February 07, 2017

RE: 0 Valley Avenue – Permit #2016-02734

Please see our responses below to your Request for Clarification for the above reference project.

**ROOF FRAMING PLAN**  
SCALE: 1/8"=1'-0"

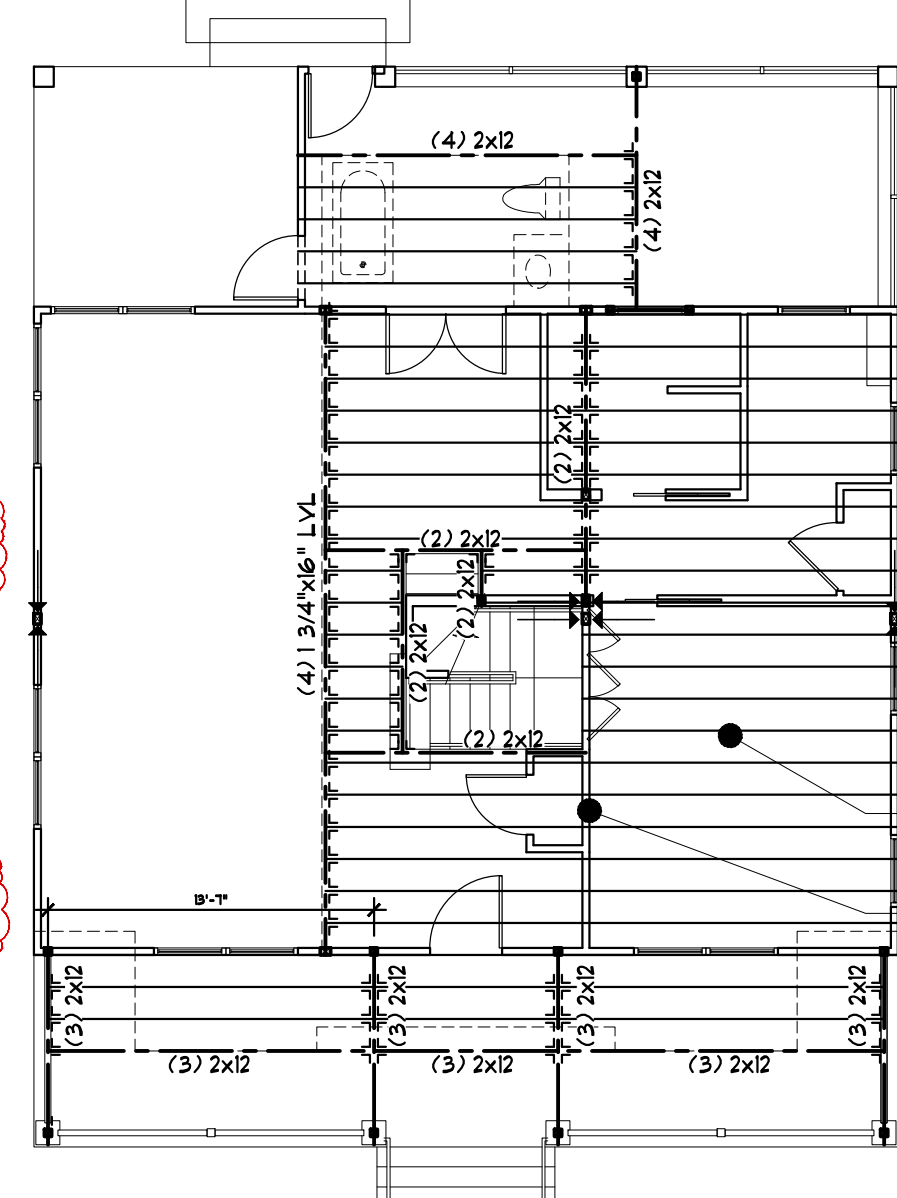
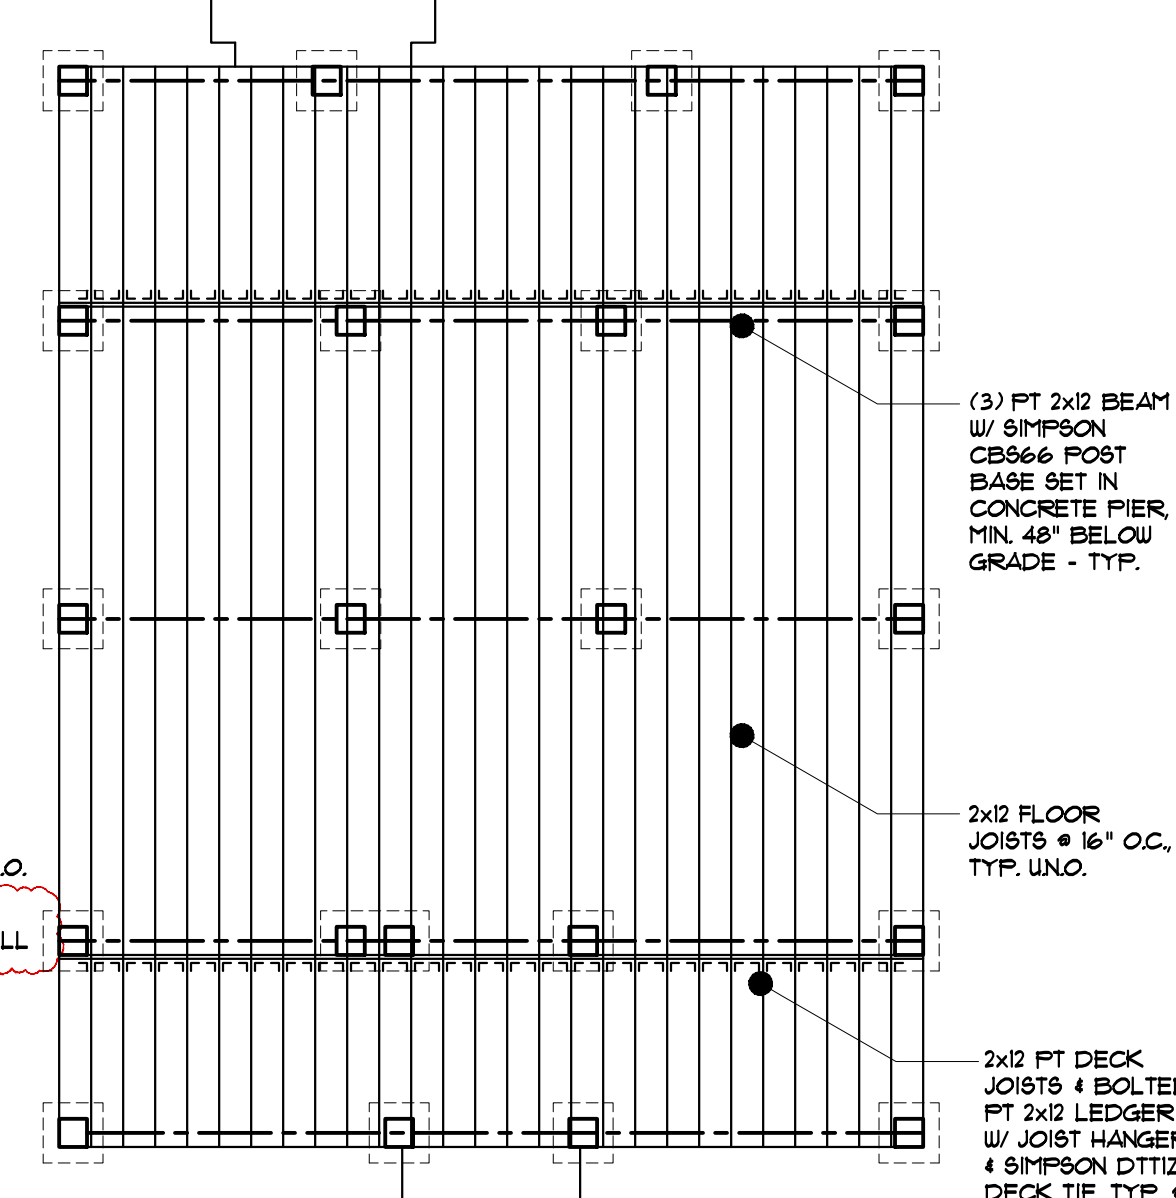
1. What is the Depth of the Footing?  
*48" below grade to meet min frost depth.*
2. What is the maximum length of the Joists on the second floor?  
*12'-6" unsupported – maximum length = 17'-0" (load bearing wall at mid span, see revised note on A-3.1).*

7. Provide window and door schedule.  
*Please see revised note on A-1.1.*
8. Provide header schedule.  
*Please see revised note on A-3.1.*
9. Show or call out locations or CO2 and smoke detector.  
*Please see locations on A-1.1 noted as 'SD/CO' located outside sleeping rooms.*

10. Provide deck connection and support details.  
*Please see detail on A-3.1.*
11. Handrail Continuity.  
*Please see revised handrail on A-1.1.*
12. What is the maximum length of the roof rafters?

*19'-0" unsupported – maximum length = 19'-3" with SPF #1 @ 16" O.C.  
Please see revised note on A-3.1 (load bearing wall at mid span, see revised note  
on A-3.1).*
